**KIRKLEES METROPOLITAN COUNCIL
INVESTMENT & REGENERATION SERVICE**

Reference No: 2020/62/92684/E

Site Address: 44, Westerley Lane, Shelley, Huddersfield, HD8 8HP

Description: Erection of single storey front extension and alterations to convert garage to living accommodation

PROPOSED GROUND FLOOR PLAN
SCALE 1:50

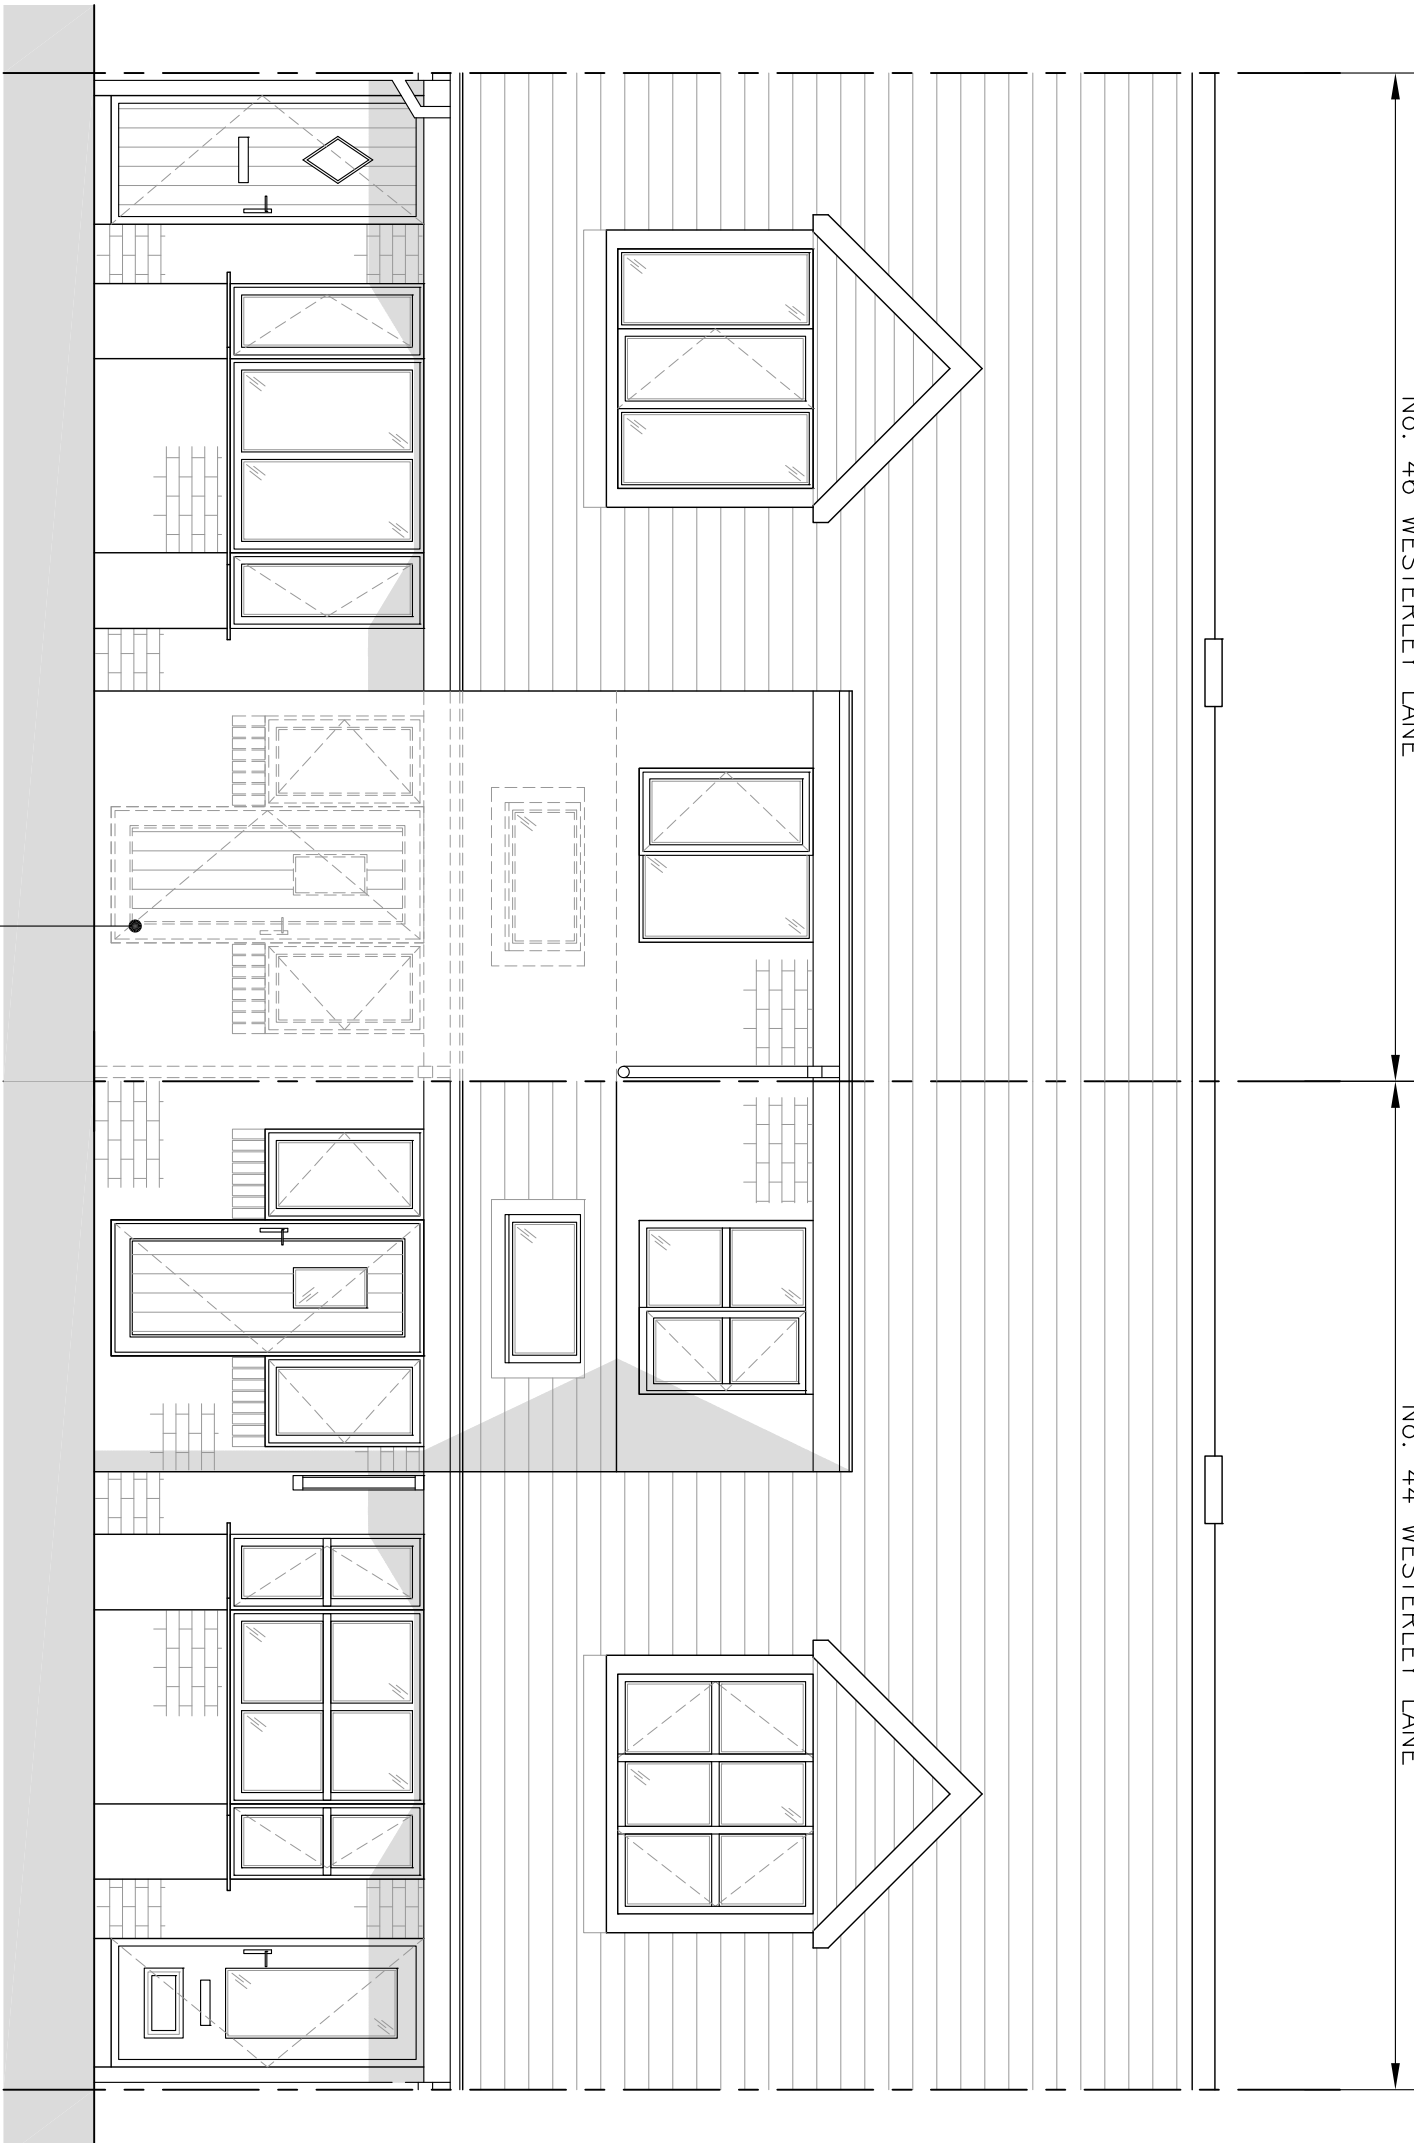
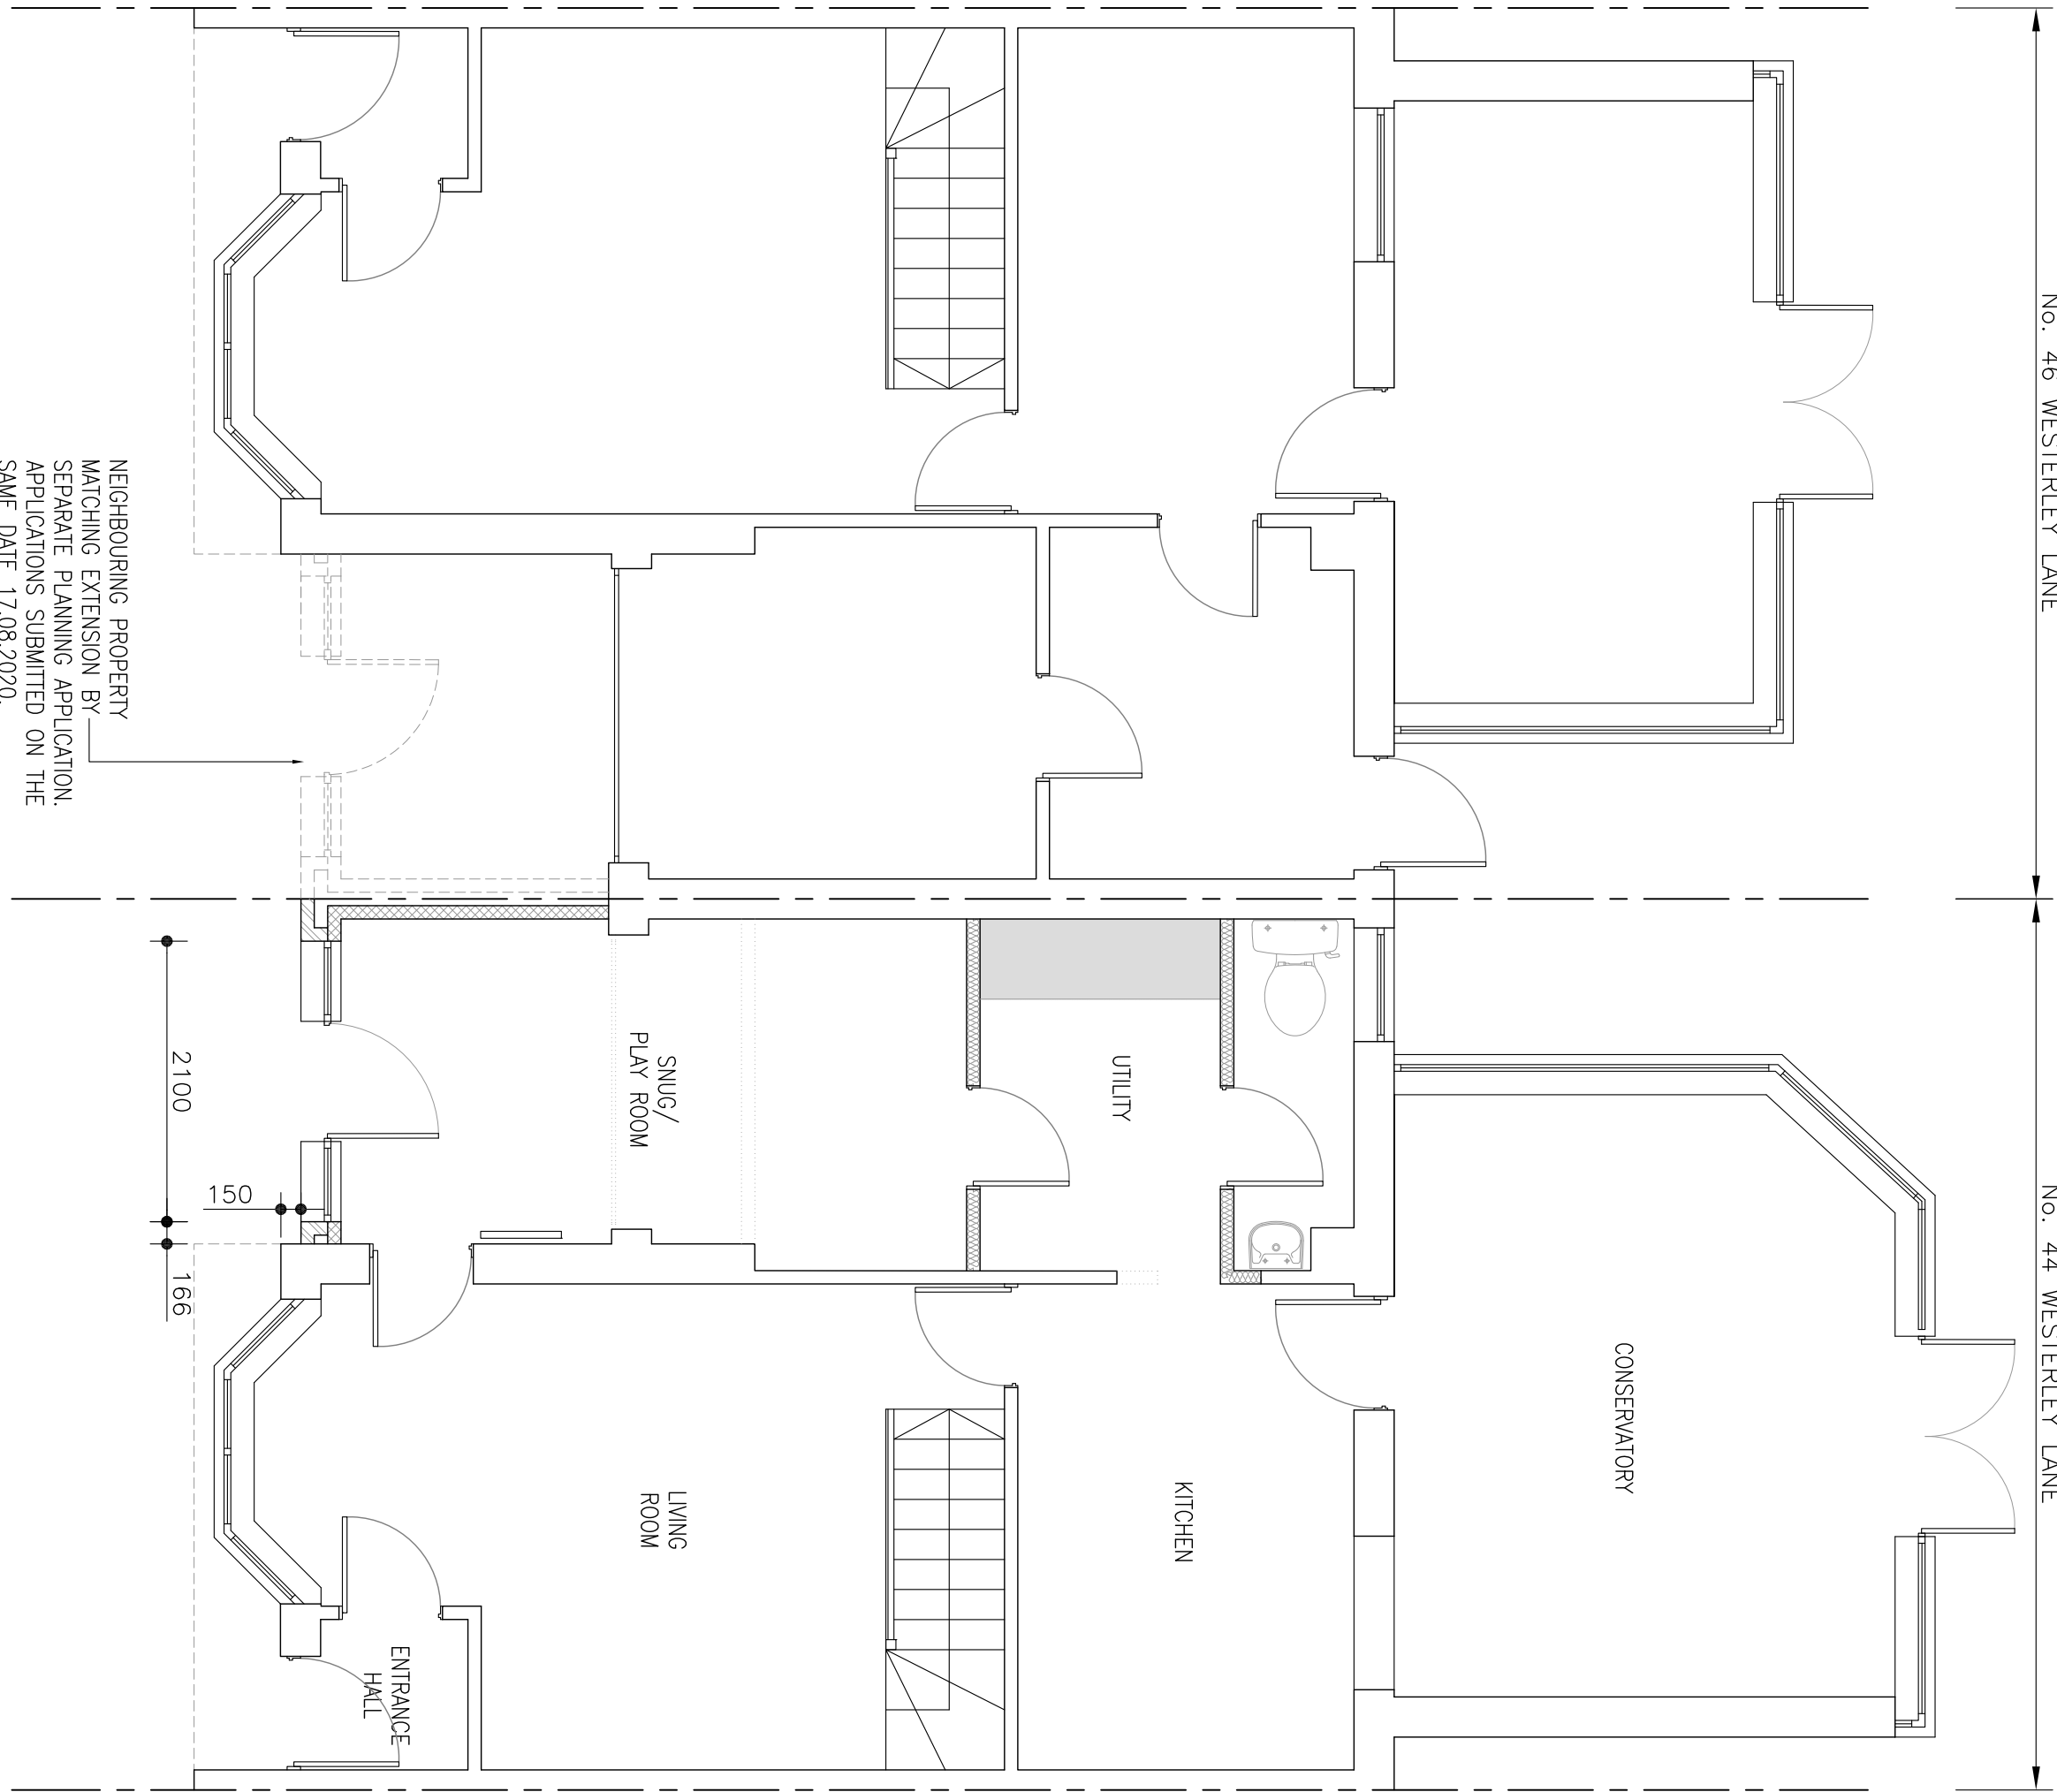
The extension would project 2.3m from the front elevation of the property and would be set back from the front most elevation by 0.15m. It would extend up to the boundary shared with the adjoining property. It would be designed with a lean-to roof form which would have an eaves height of 2.4m and a maximum height of 3.4m.

The opening to the rear of the existing integral garage, which the submitted plans show is currently used as a snug/playroom, would be replaced with a window.

The proposed extension would project 2.3m along the boundary shared with the adjoining property. The extension would be located alongside existing garage doors and back slightly in relation to the habitable ground floor openings of the property. Taking this into consideration, along with the projection and single-storey nature of the extension, it is considered that there would be no harmful overbearing or overshadowing impact. Whilst no openings are proposed for the side elevation of the extension, it is considered appropriate to condition that no openings shall be installed in the future to prevent harmful overlooking. It is noted that application reference 2020/92678 for a similar development is currently being considered at this property.

The door to the rear of the integral garage would be replaced with an opening to serve a WC. It is considered that this use, as well as the distance retained, would be sufficient to prevent harmful overlooking to the property to the rear.

4. Notwithstanding the provisions of the Town and Country Planning (General Permitted Development) Order 2015 as amended (or any Order revoking or re-enacting that Order) no doors, windows or any other openings (apart from any expressly allowed by this permission) shall be created in the side elevation of the single storey front extension hereby approved.

PROPOSED SITE PLAN
SCALE 1:250

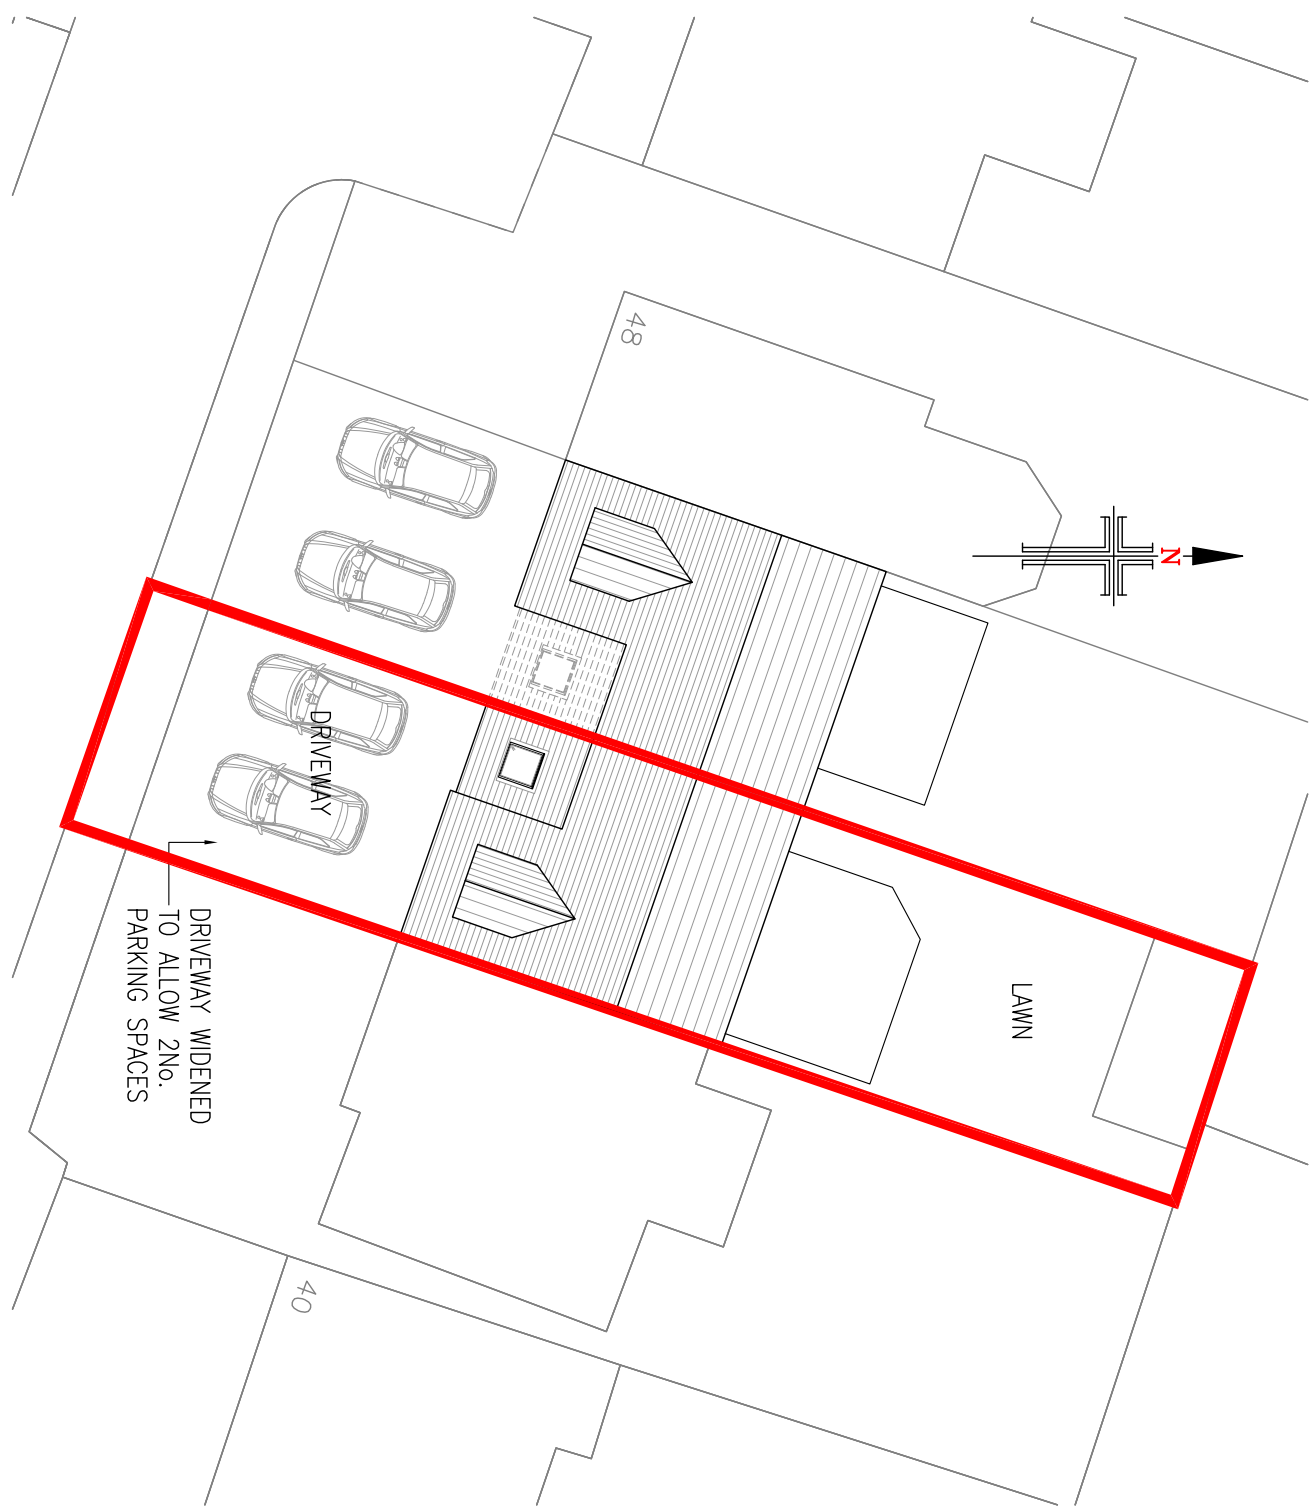
The extension would result in the loss of the integral garage. However, this is shown on the submitted plans to be used as a snug/playroom. The plans indicate that the driveway would be extended to accommodate two off-street parking spaces following development. As the existing parking provision would be retained, this is considered acceptable. As such, the scheme would not represent additional harm in terms of highway safety complying with Policies LP21 and LP22 of the Kirklees Local Plan.

5. Before the extension is first brought into use, the area indicated for parking on the submitted/listed plans shall be finished in a hardened and drained surface in accordance with the Communities and Local Government; and Environment Agency's 'Guidance on the permeable surfacing of front gardens (parking areas)' published 13th May 2009 (ISBN 9781409804864) as amended or any successor guidance. Notwithstanding the provisions of the Town and Country Planning (General Permitted Development) Order 2015 as amended (or any Order revoking or re-enacting that Order) this shall be so retained, free of obstructions and available for parking thereafter. **Reason:** In the interests of amenity and traffic safety, to ensure adequate space within the site for vehicle movements and parking and in accordance with Policy LP22 of the Kirklees Local Plan.

PROPOSED EAST FACING ELEVATION
SCALE 1:50

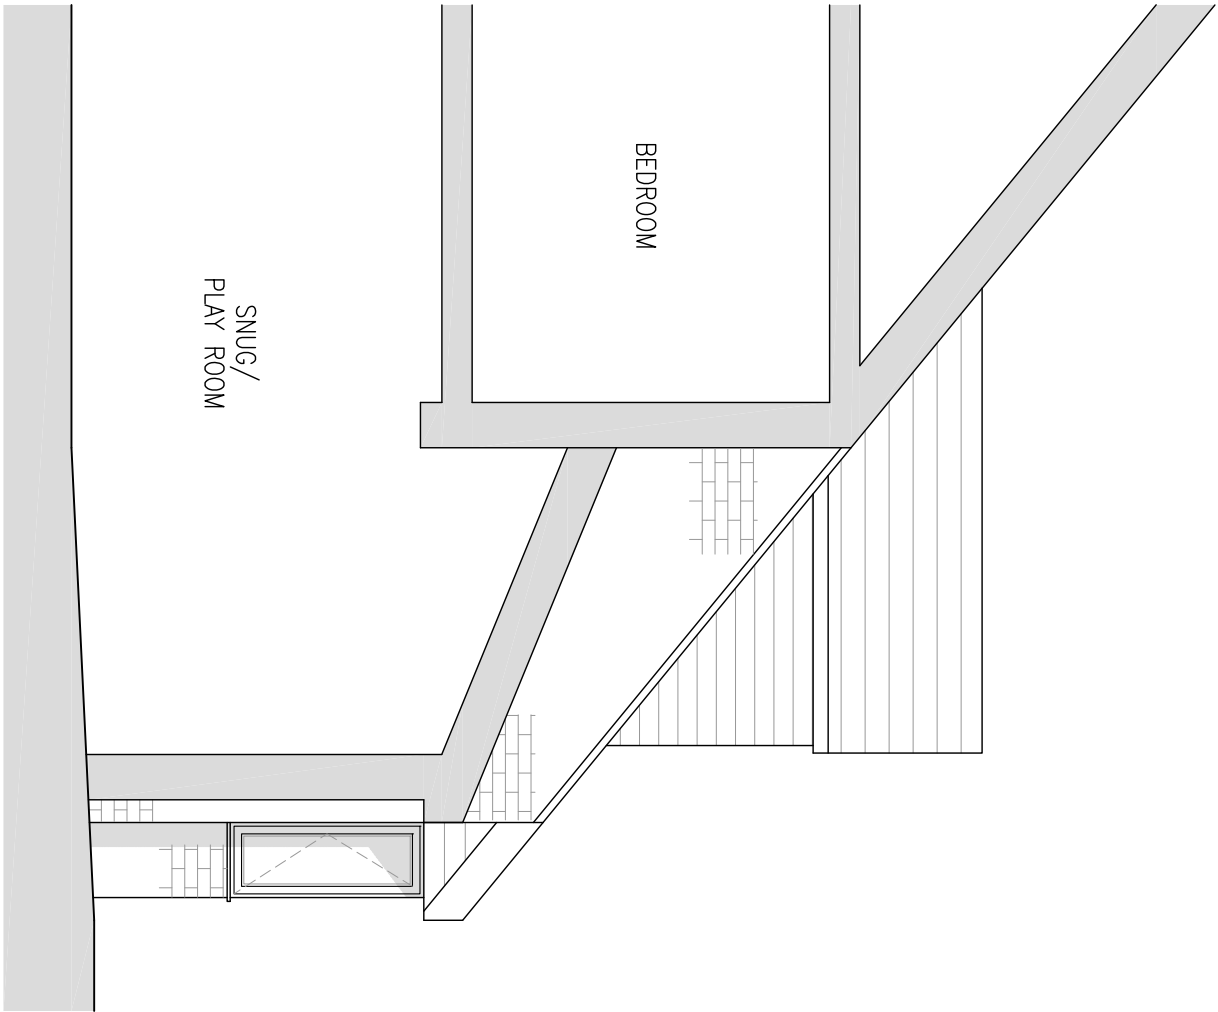
The proposed extension would be located to the front of the dwelling and is substantially larger than what would usually be supported on the principle elevation of a dwelling. In this case, it is noted that the front elevation of the property is staggered, and the extension would not project beyond the front-most elevation of the property. The extension would be finished in materials to match existing and is considered in-keeping with the host dwelling in terms of its design. It is considered, due to its overall scale and design, that the extension would not appear overly dominant on the front elevation and would remain subservient to the existing dwelling.

Whilst the extension would be visible within the street-scene, the extension would not project beyond the front-most element of the property, which is set back in relation to Westerley Lane. This, along with the fact that extension would sit roughly in line with the principle elevations of the dwellings to the north of Westerley Lane, is considered to reduce its prominence within the street-scene and the surrounding area.

3. The external walls and roofing materials of the extension hereby approved shall in all respects match those used in the construction of the existing building.
